Colorado Geological Survey review of Sterling Ranch Filing No. 2 (Phase 1) Final Plat SF2015 Resubmittal 2 (Amy Crandall, acrandall@mines.edu):

The available referral documents include a revised Soil, Geology, and Geologic Hazard Study, Copper Chase and Sterling Ranch Filing No. 2 (Entech Engineering, Job No. 191088, Revised March 18, 2021), a set of Grading & Erosion Control Plans (JR Engineering, April 15, 2021), a set of six Sterling Ranch Filing No. 2 Final Plat sheets (JR Engineering, May 24, 2021), and other documents.

Figure 7: Geology Map/Engineering Geology map

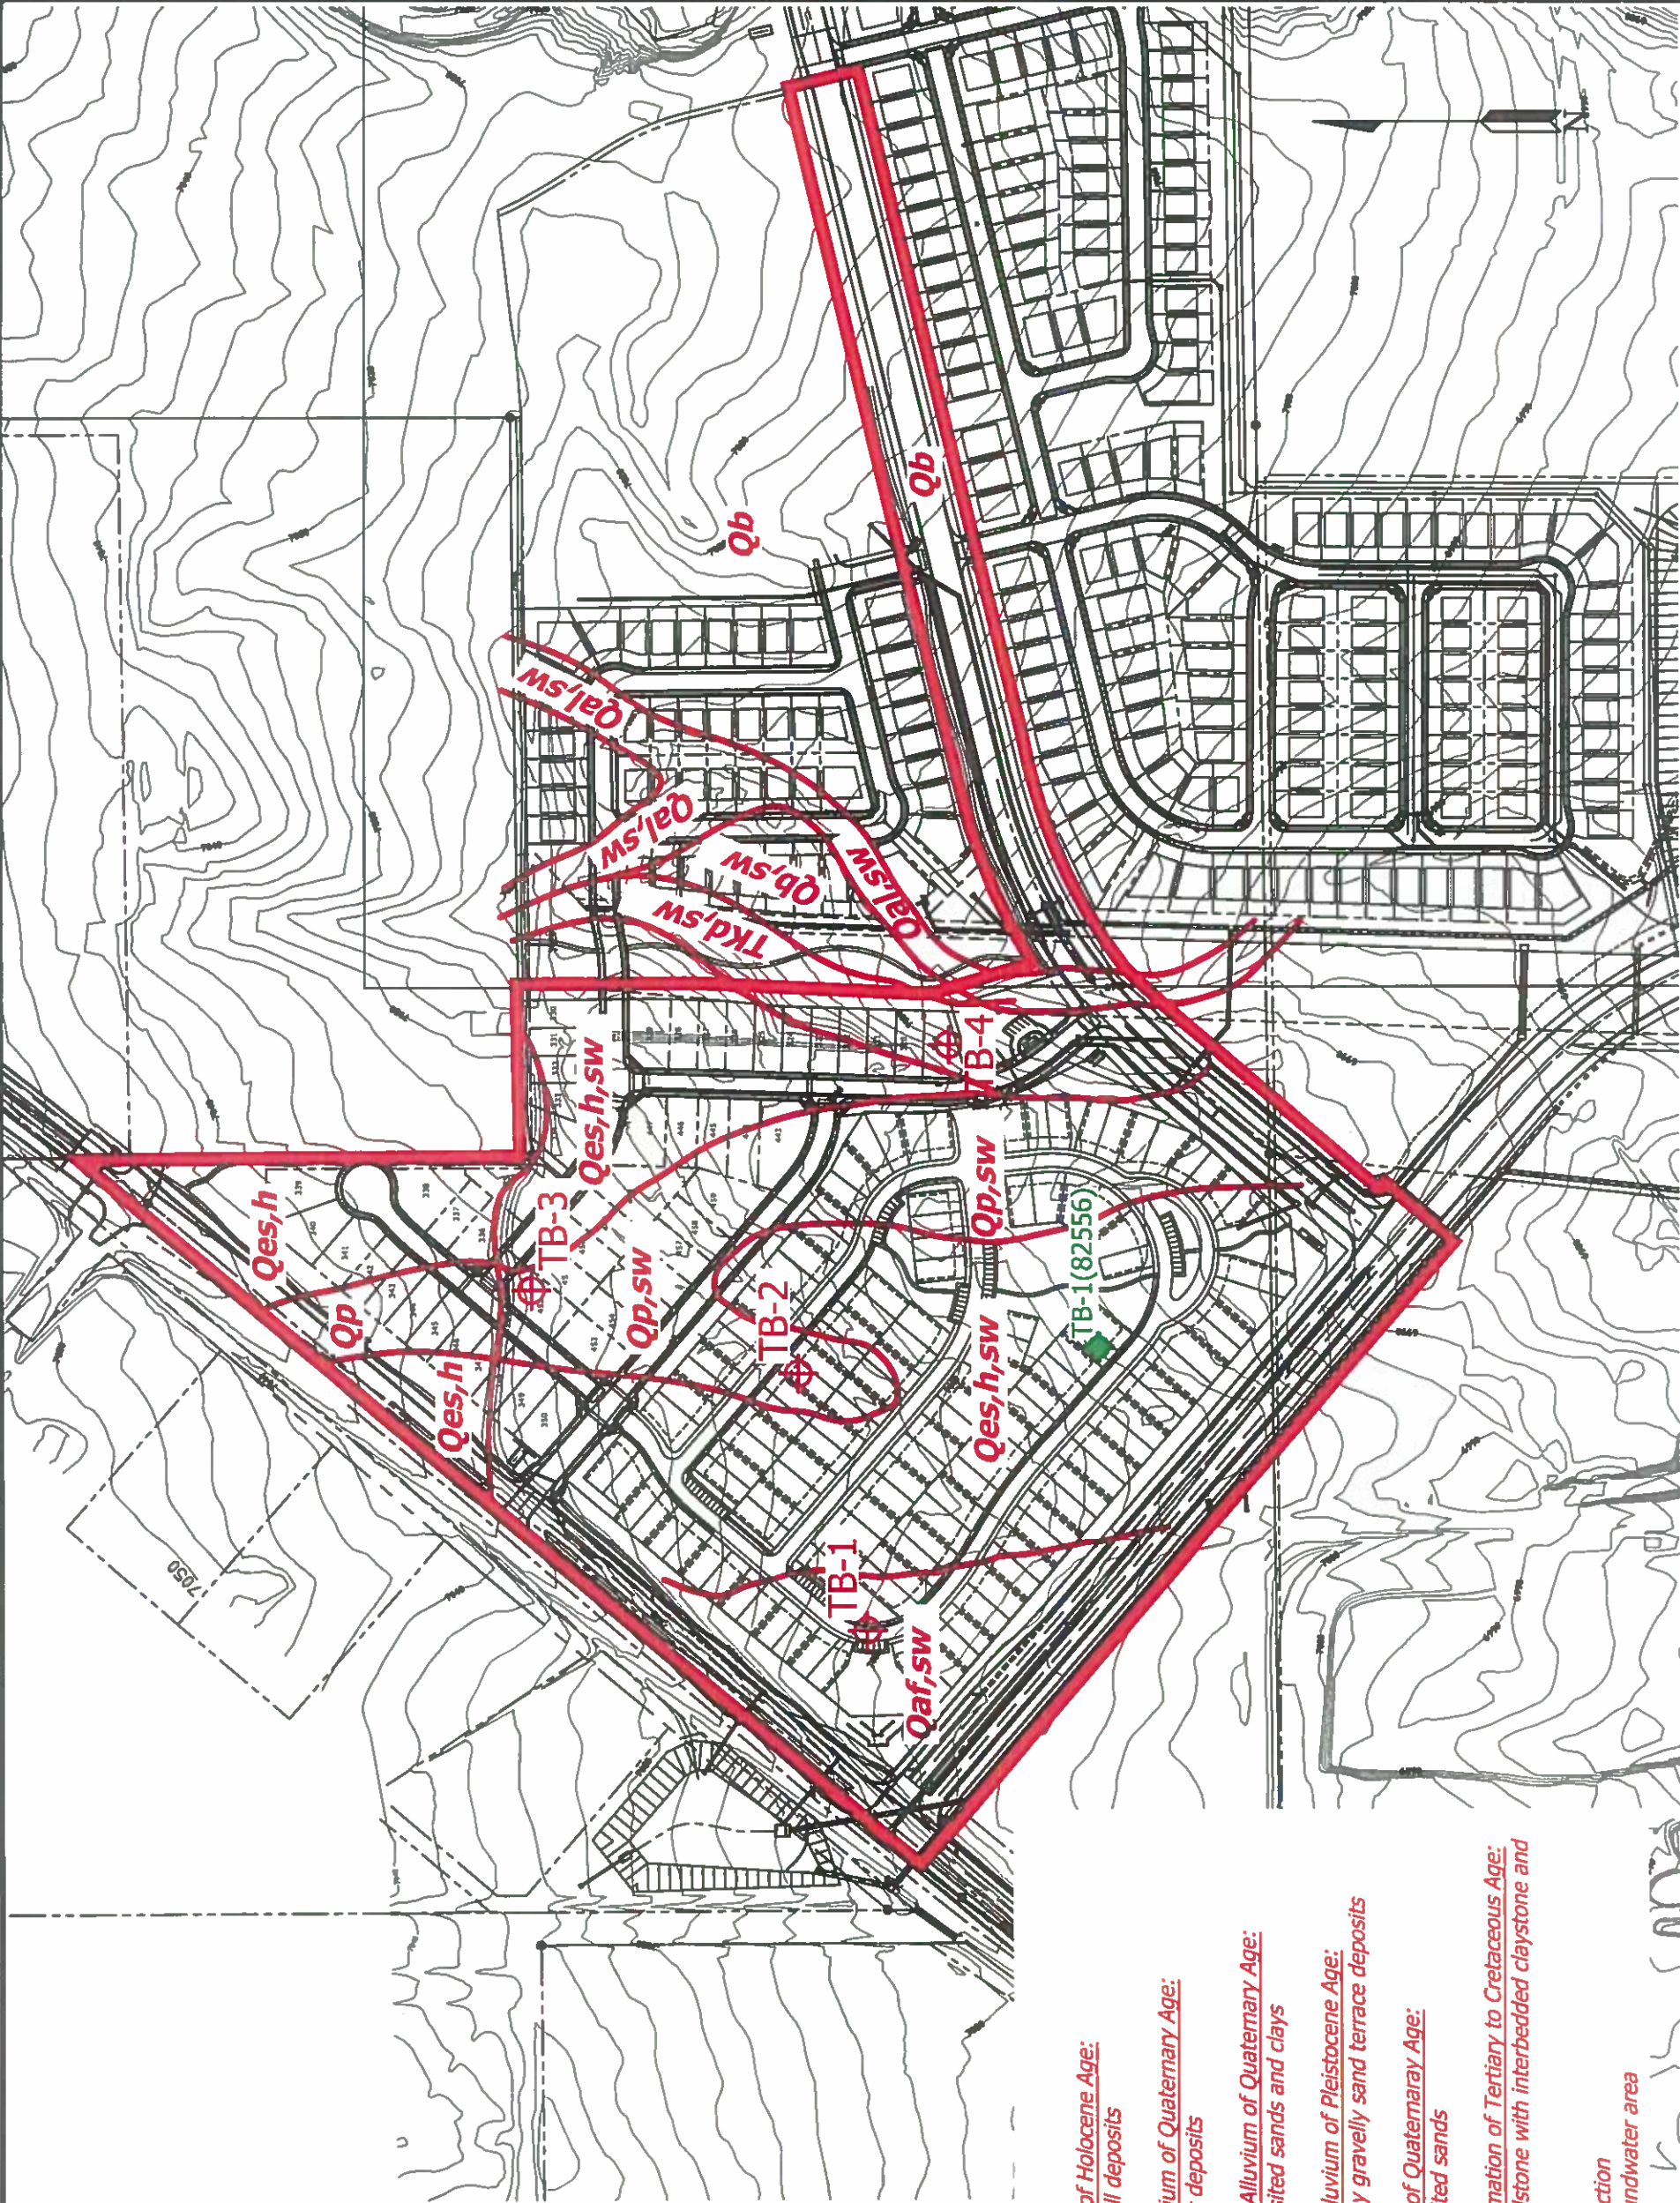
1. Entech's water level data do not support their characterization of the site's shallow groundwater condition as "seasonal." Entech's Figure 7, plat note 26 on sheet 2, and sheet 7 of the plat should be corrected to identify the entire Sterling Ranch Filing No. 2 (Phase 1) site as a shallow groundwater area.

- The "seasonal" designation was removed in Entech's Figure 7 and their revised report. However, we recommend the entire Sterling Ranch Filing No. 2 (Phase 1) site is designated as a shallow groundwater area and updated on the final plat (note 26). Sheet 7 was not included in the updated final plat drawings (May 24, 2021).
